Planning Inspectorate (the Drovers Solar
Farm)

Reference: OR-0009338/01
Customer reference: EN0110013

**Deadline 3 submissions response letter
The Drovers Solar Farm**

This letter constitutes the Environment Agency's Deadline 4 response regarding the Deadline 3 submissions. It is structured as follows:

DRAWING TITLE:  
ES Figure 12.16 Maximum Foundation  
Extents for Minimum Groundwater Level

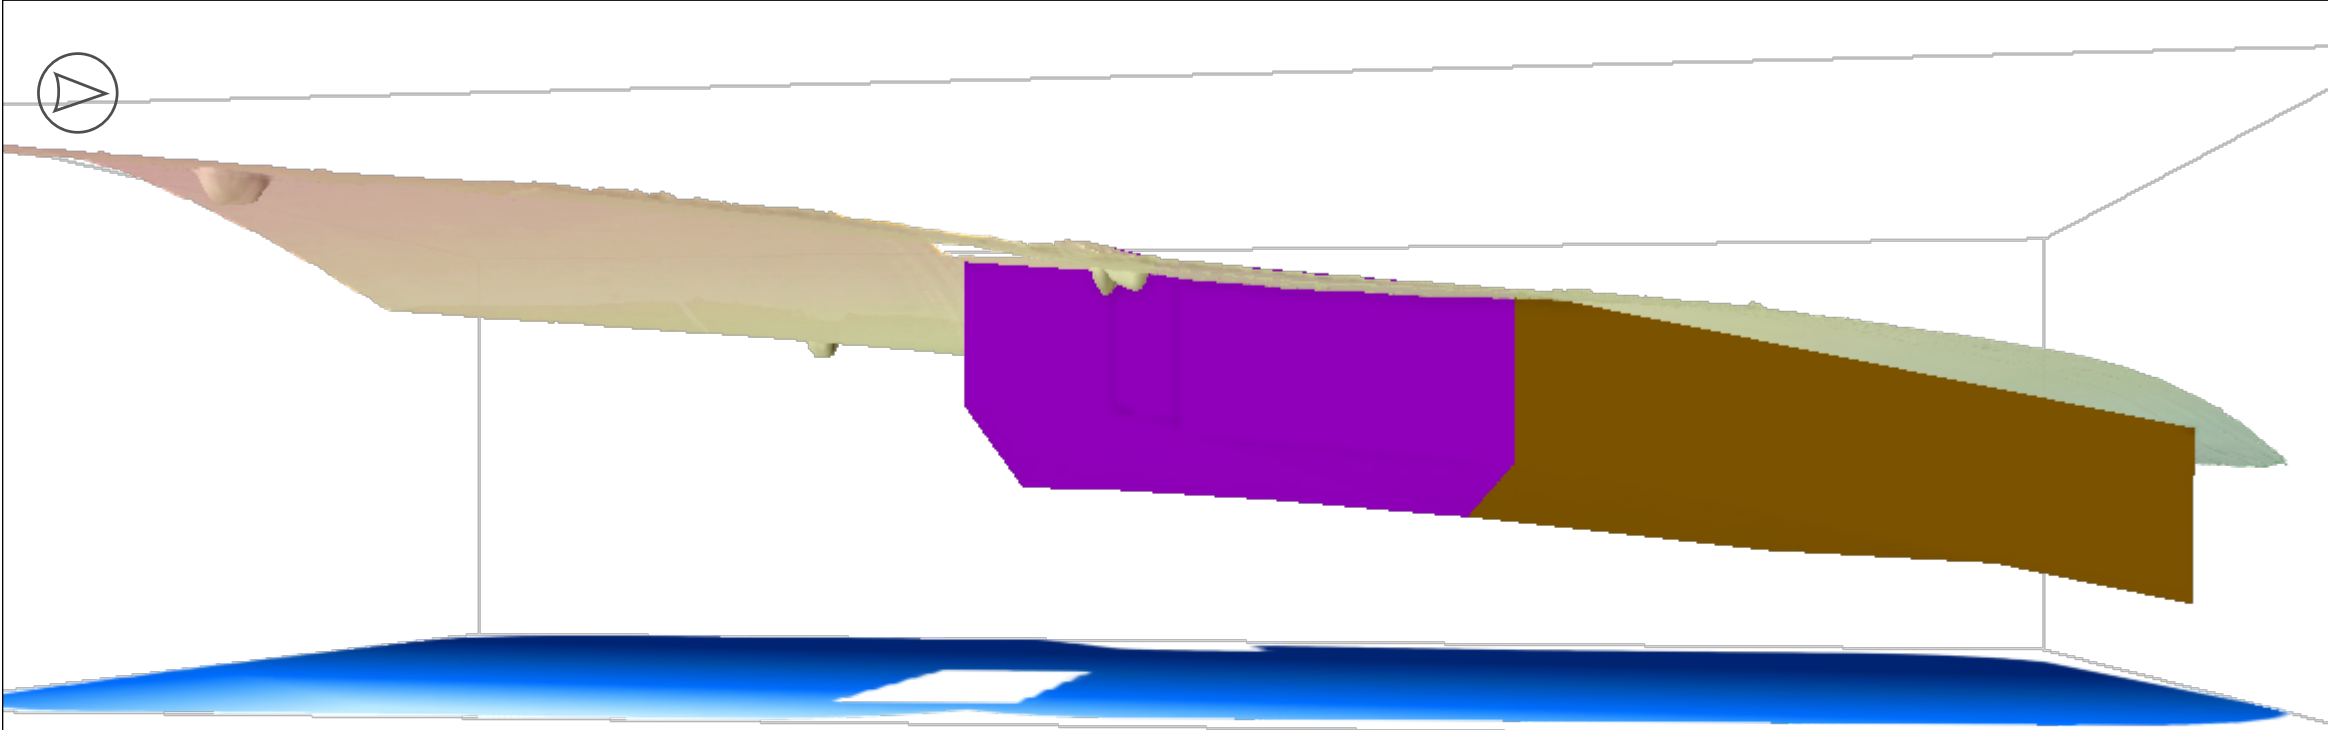
We were concerned that figures 12.13 [[APP-127](#)], 12.14 [[APP-128](#)], 12.15 [[APP-129](#)] and 12.16 [[APP-130](#)] do not clearly define the area represented by the drawings, including view orientation, or the elevation values.

DRAWING TITLE:
Figure 12.7: Triangulated Baseline Groundwater Elevation

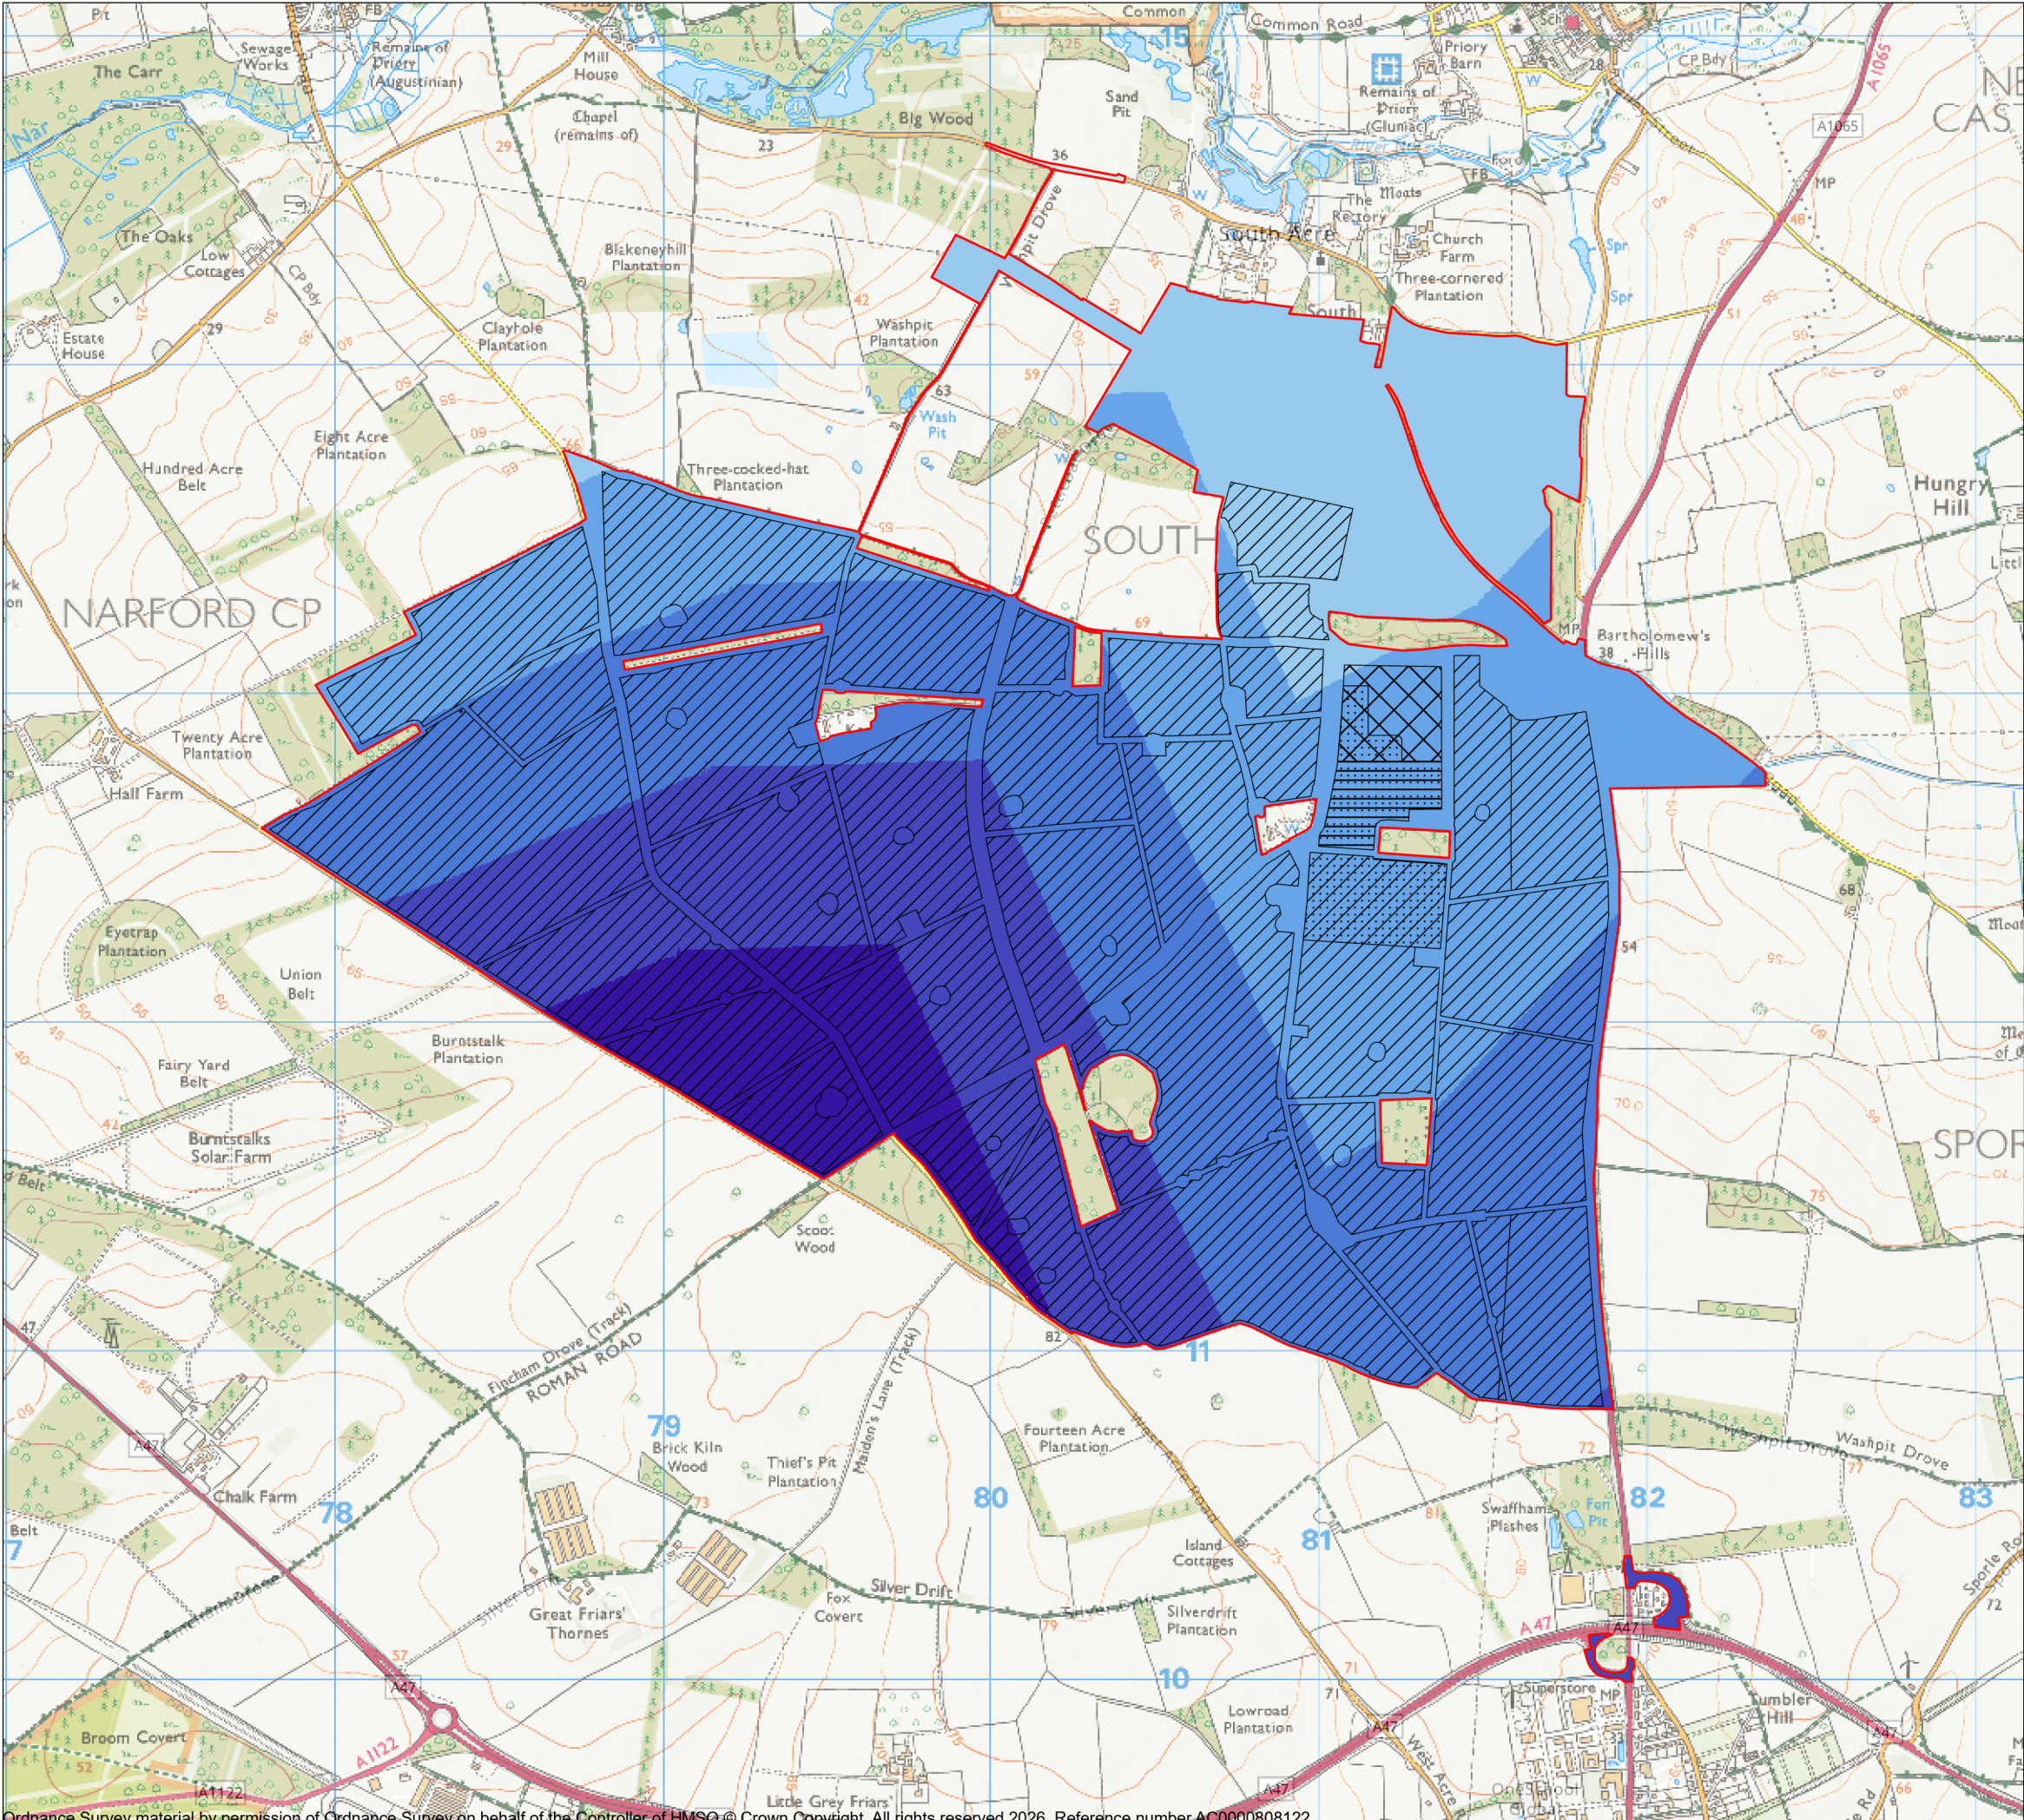
We were concerned that 6.3 Environmental Statement Figure 12.7 3D Representation of Groundwater [\[APP-121\]](#) is difficult to interpret, which limits its value. We requested additional views of the modelled area, with a clearer indication of view orientation and contouring of the groundwater surface, if applicable.

The baseline groundwater elevations are subdivided into 6 ranges in the key but only 5 categories are visible in the figure - looks like the 45.001-50 category is the one not represented visually.

- 6.3.1 ES Figure 12.7 Triangulated Baseline Groundwater Elevation [[REP3-048](#)]
- 6.3.1 ES Figure 12.8 Depth to Triangulated Baseline Groundwater Elevation [[REP3-049](#)]
- 6.3.1 ES Figure 12.9 Depth to NEAC Groundwater Wet Conditions [[REP3-050](#)]

We are content to resolve this issue.

DRAWING TITLE:
Figure 12.12: Drinking Water Protection Designations

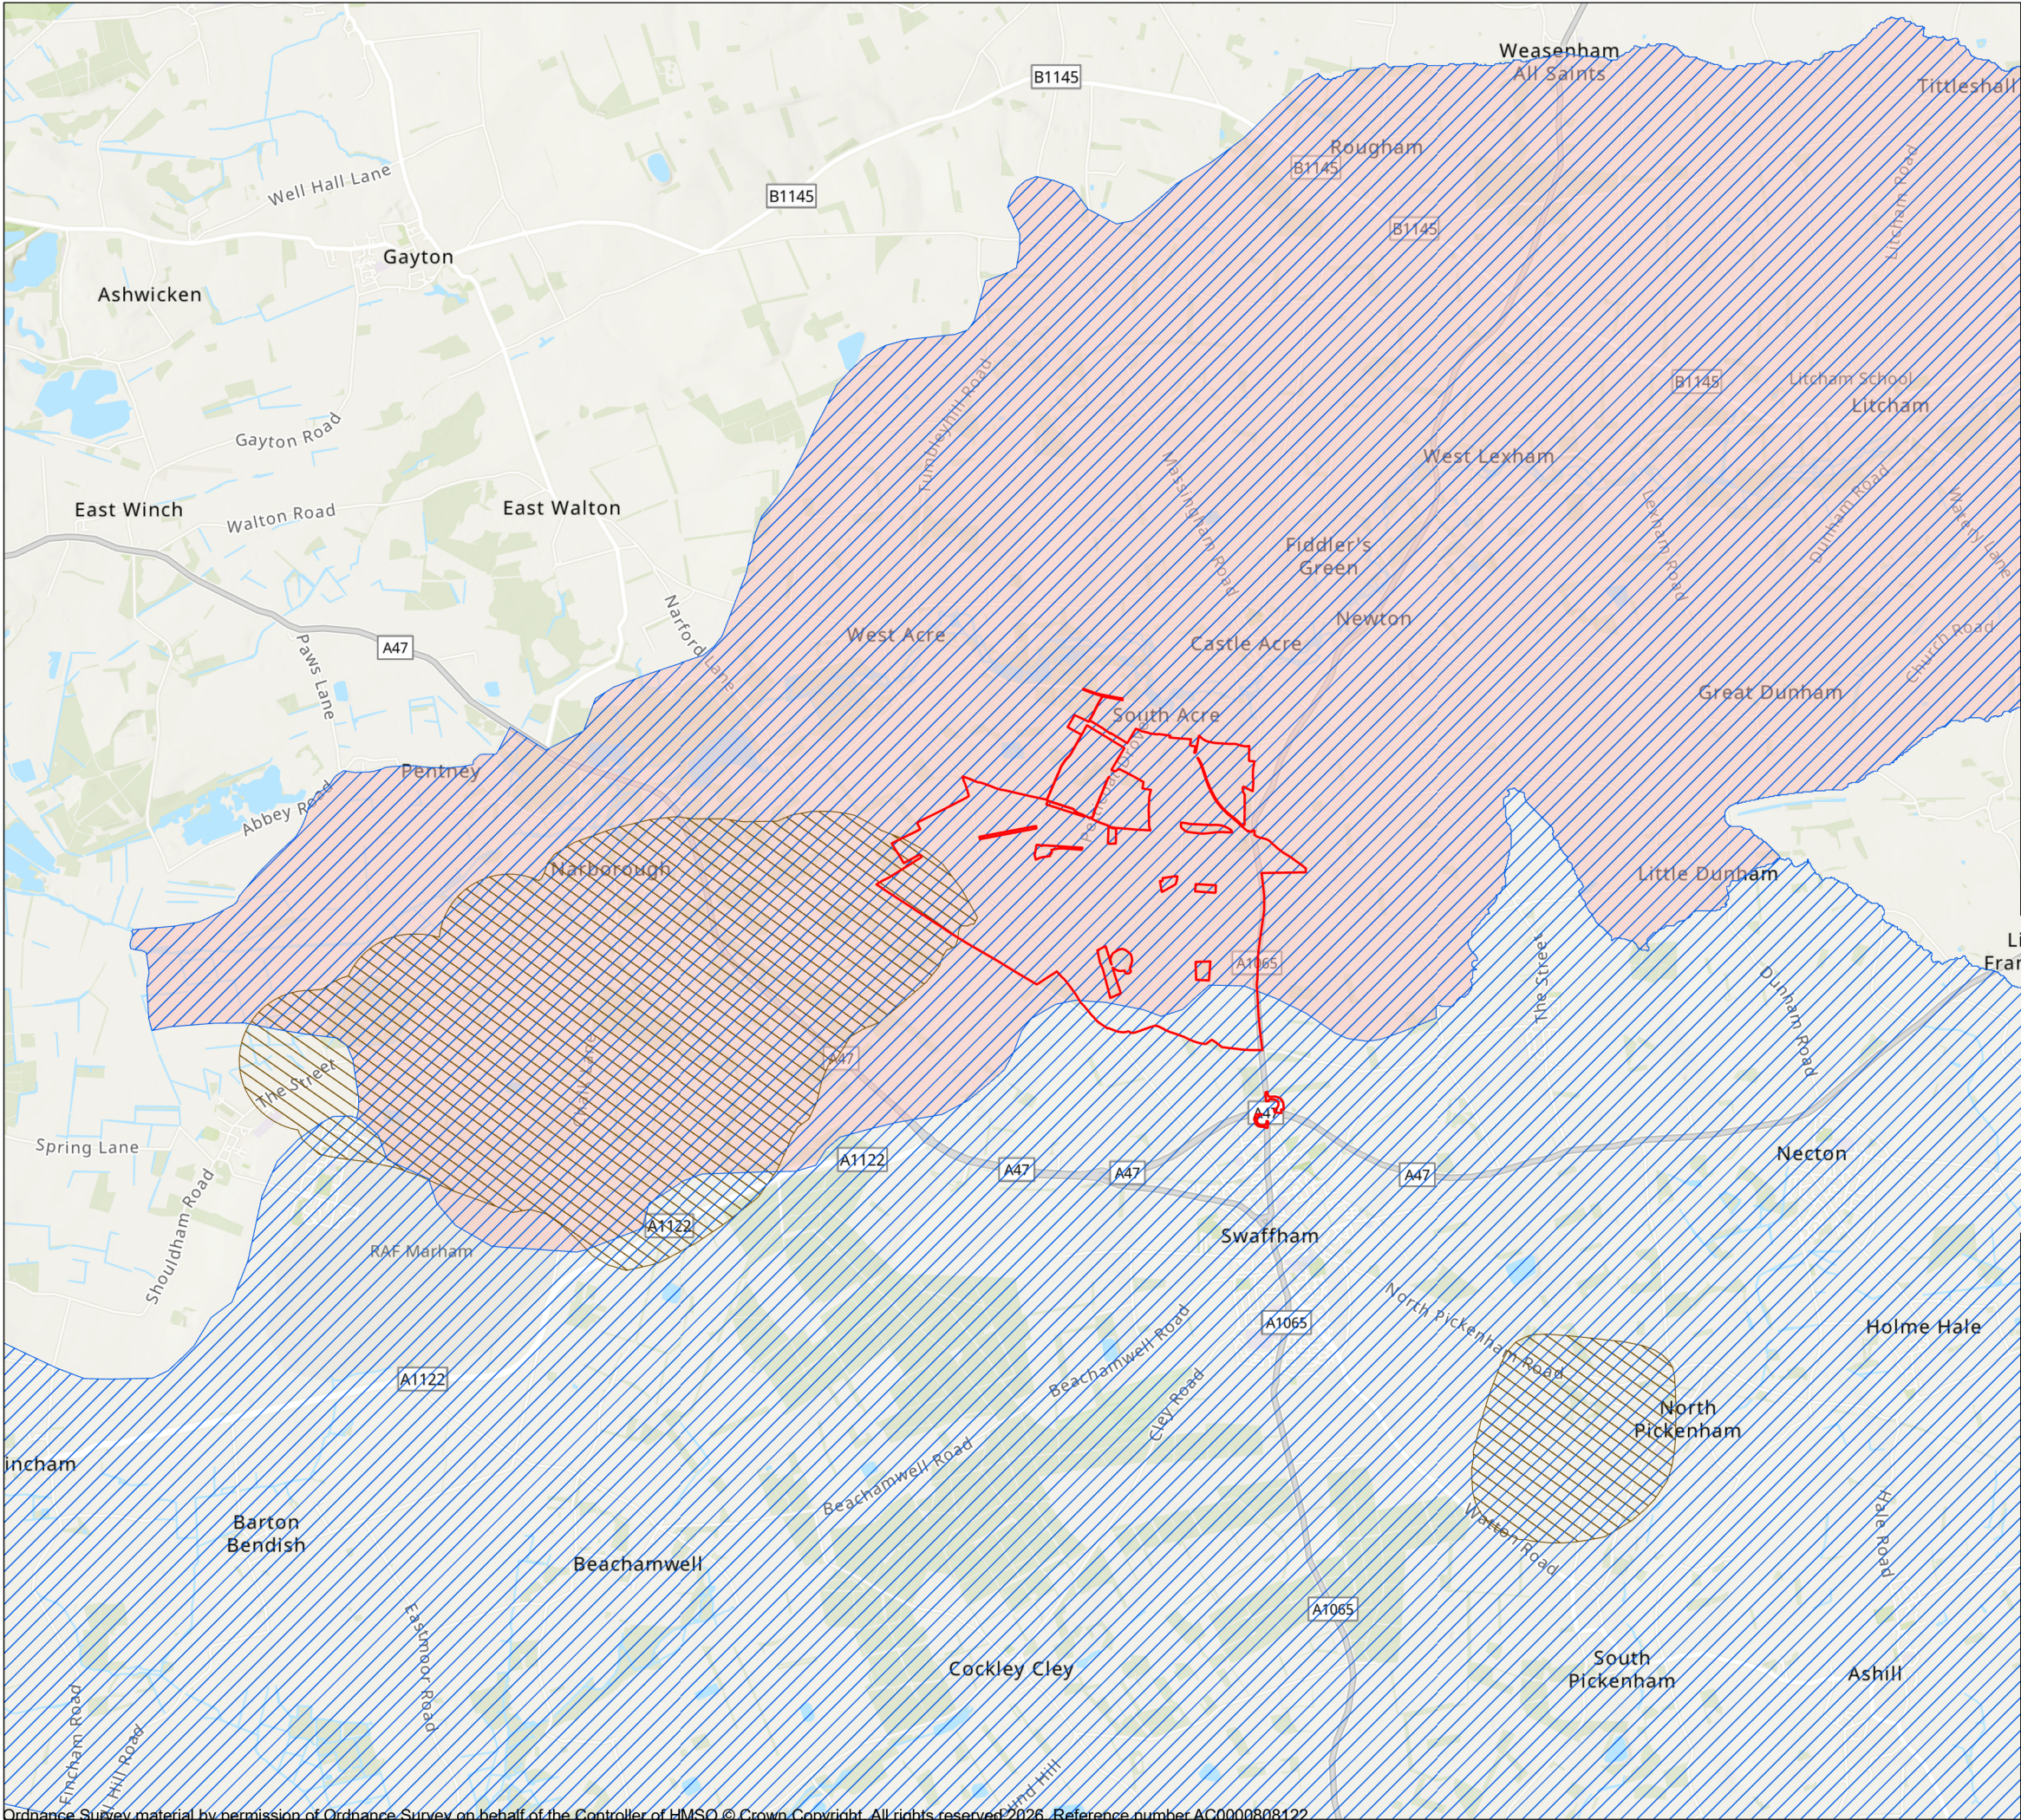
We were concerned that Figure 12.12 [\[APP-126\]](#) does not show all of the drinking water protection designations, including the Drinking Water Surface Water Safeguard Zone and Drinking Water Groundwater Safeguard Zone. The reader is therefore unable to see these designations in the context of the draft Order Limits.

6.3.1 ES Figure 12.12 Drinking Water Protection Designations [\[REP3-042\]](#) has been updated sufficiently.
